Planning Application Ref: BN/128/19/OUT

Location: Land Adjacent to Highfield House, Yapton Road, Barnham, PO22 0AZ

Description of works: Application for outline planning permission for development of 70 bed Care Home and 14 Assisted Living bungalows with associated car parking, landscaping and access - Departure from the Development Plan

DATE  
JULY 2019  
JOB / DRWG No  
1693 / SP1

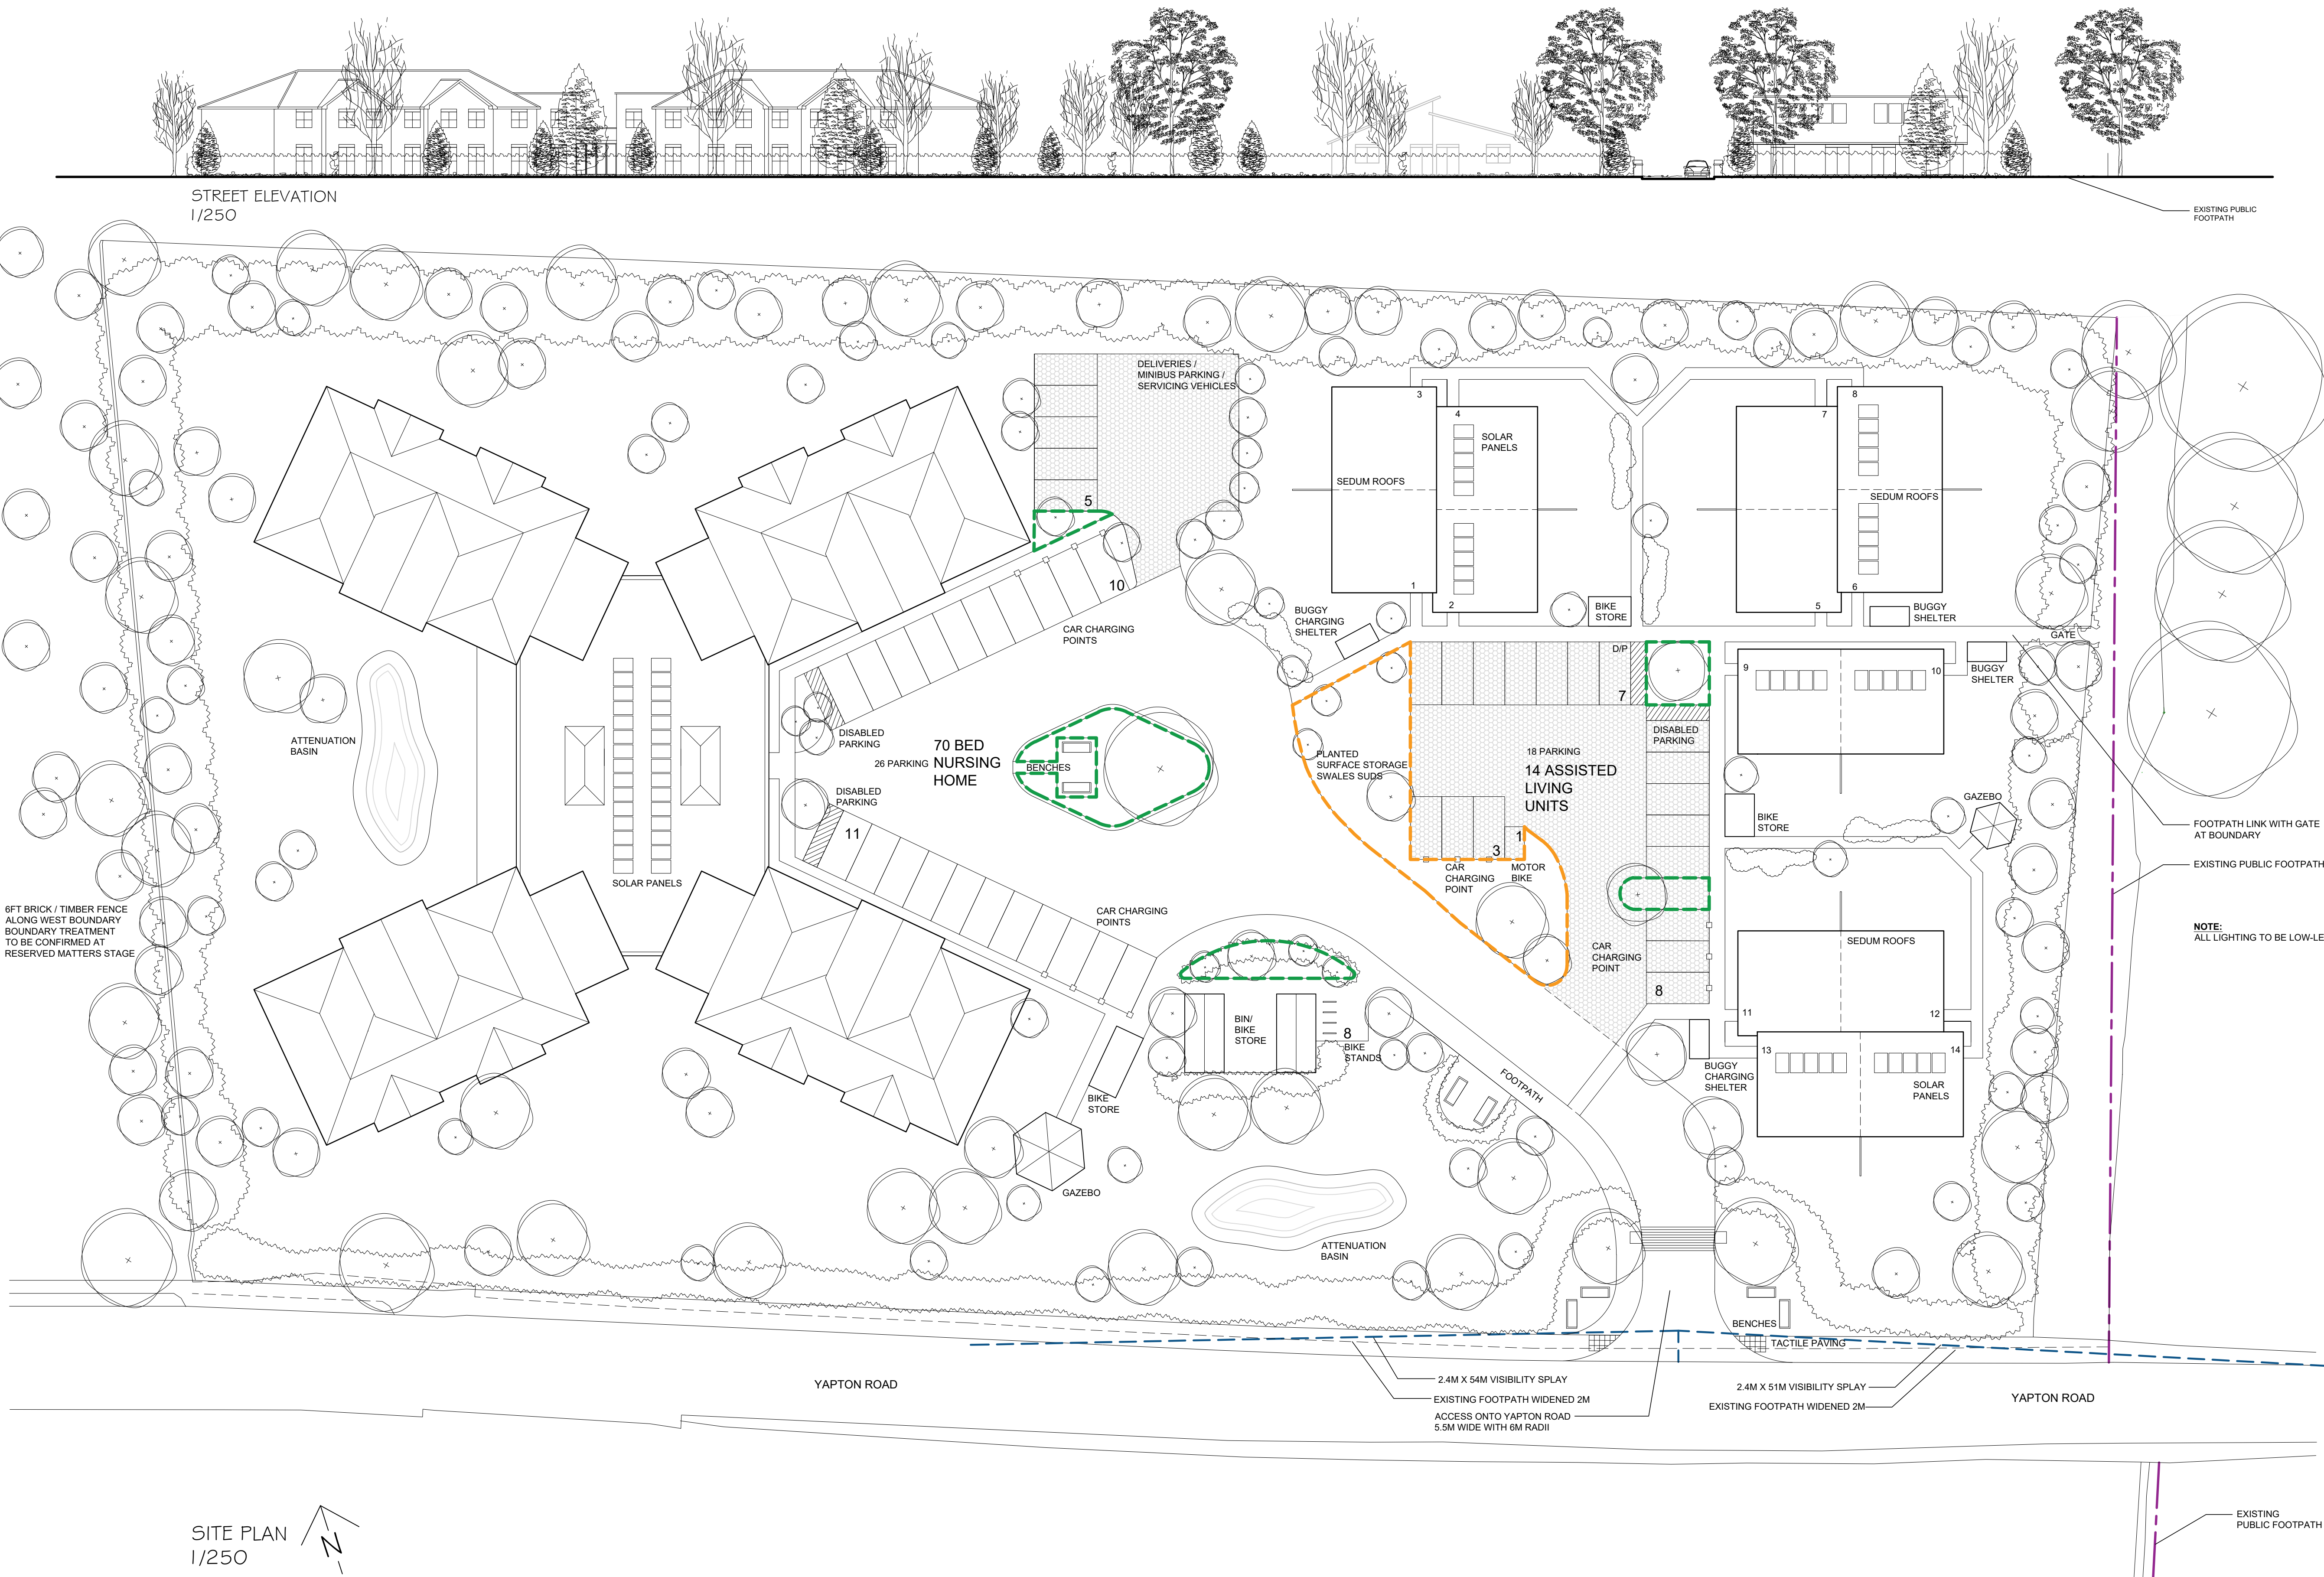
- Roadside hedgerow and trees contribute greatly to the character of the area and their future growth and influence should be a major consideration in designing a site layout.

- I see no obvious problem with the proposed location of the main access to site, although inevitably a substantial section of the boundary hedge-line will need to be removed to achieve adequate vehicle sightlines. That can and should be mitigated with an ambitious, detailed landscape plan that enhances the existing hedgerow coverage and so compensates in some way for the loss of connectivity.

1. The applicants will need to employ the services of an Arboricultural Consultant to carry out a tree survey exercise and then prepare an Arboricultural Impact Assessment (AIA) which must be inclusive of; a 'Tree Survey Schedule', a 'Root Protection Area (RPA) Schedule' and a 'Tree Constraints Plan' – with the trees accurately plotted on same.
2. In the event that a RPA of any tree which is proposed for retention overlaps the development then BS5837:2012 requires that the Detailed Planning Application is accompanied by an Arboricultural Method Statement (AMS) and also most importantly a Tree Protection Plan – to both describe and illustrate the mitigation measures which are to be employed to ensure that the trees survive without detriment to their vigour and vitality and are given adequate protection both above and below ground.
